Rezoning Transportation Analysis

Petition Number: #2022-168

General Location Identifier: 06504502, 06504503

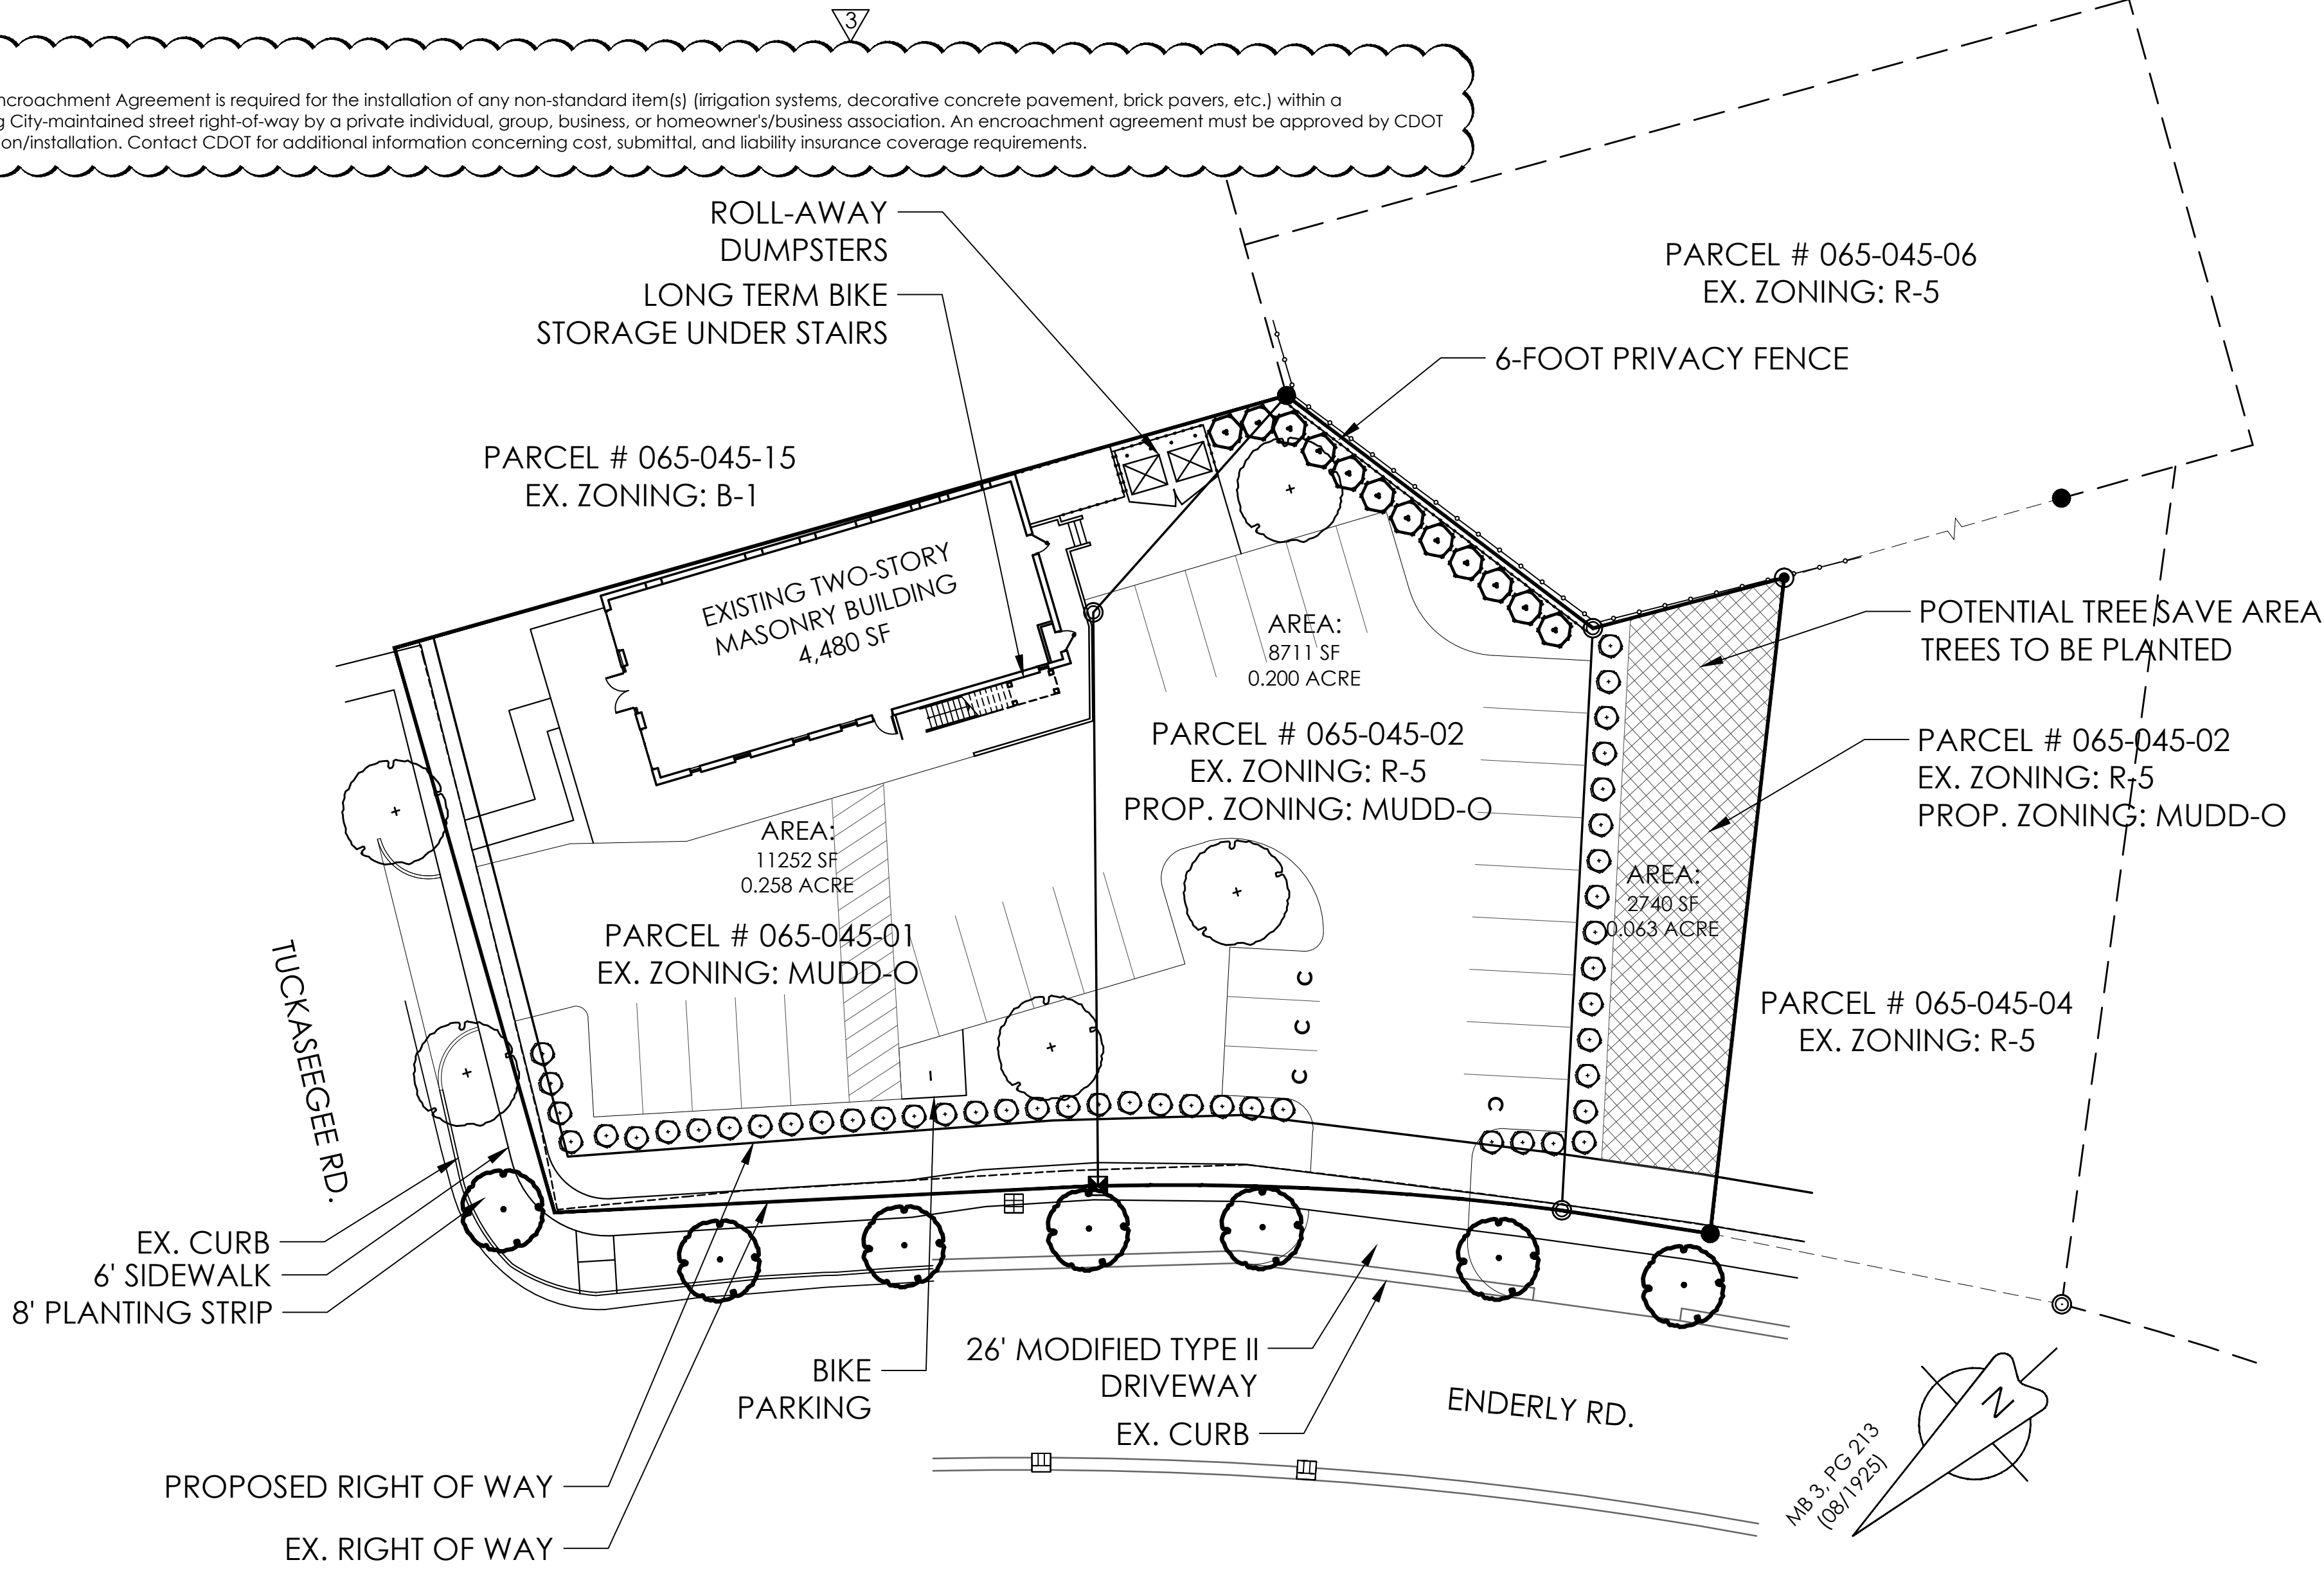
1. ~~Curbline:~~

a. ~~**Outstanding Comment from 02-22-23: Tuckaseegee Road:** Location of curb and gutter to be moved to 27 feet from roadway centerline to accommodate the Charlotte Streets Map with a roadway typical section of a 2+ Avenue, Buffered/Separated Bike Lanes. Show future curb line on site plan and dimension planting strip and sidewalk from the future back of curb location.~~

b. ~~**Enderly Road:** The future location of curb and gutter is in its existing location.~~

~~NOTE: Additional distance from center line to back of curb may be required in locations where a median is present or around intersections and interchanges.~~

~~**Outstanding Comment from 02-22-23:** Label and dimension the curb and gutter from the centerline for each road on the site plan.~~

3. ~~Revise site plan to commit to dedicate 40 feet of right of way from the Tuckaseegee Road centerline. The site plan shall label and dimension the right of way from the road centerline.~~

4. ~~Revise site plan to commit to dedicate 36 feet of right of way from the Enderly Road centerline. The site plan shall label and dimension the right of way from the road centerline.~~

5. ~~**CDOT REQUEST:** that site plan and conditional note(s) revisions are made to commit to construct an 8-foot planting strip, and 8-foot sidewalk on Tuckaseegee Road to match the overall city plan for this street section per Charlotte Streets Map. The site plan shall label and dimension both items from the future back of curb and gutter. The wider sidewalk also meets the Charlotte WALKS Policy~~

- ~~6. **Outstanding Comment from 02-22-23:** Add a conditional note specifying "A Right of Way Encroachment Agreement is required for the installation of any non-standard item(s) (irrigation systems, decorative concrete pavement, brick pavers, etc.) within a proposed/existing City-maintained street right-of-way by a private individual, group, business, or homeowner's/business association. An encroachment agreement must be approved by CDOT prior to construction/installation. Contact CDOT for additional information concerning cost, submittal, and liability insurance coverage requirements."~~

- ~~7. Add a conditional note specifying "the Petitioner shall dedicate and convey in fee simple all rights-of-way to the City before the site's first building certificate of occupancy is issued. CDOT requests rights-of-way set at 2' behind back of sidewalk where feasible."~~

- ~~8. Revise conditional note specifying "All transportation improvements will be approved and constructed before the site's first building certificate of occupancy is issued. The petitioner may phase transportation improvements if said improvements and phasing are explicitly described in site plan notes."~~

- FROM THE ISSUANCE OF A CERTIFICATE OF OCCUPANCY FOR THE BUILDING
8. ALL TRANSPORTATION IMPROVEMENTS SHALL BE APPROVED AND CONSTRUCTED PRIOR TO THE ISSUANCE OF A CERTIFICATE OF OCCUPANCY FOR THE BUILDING
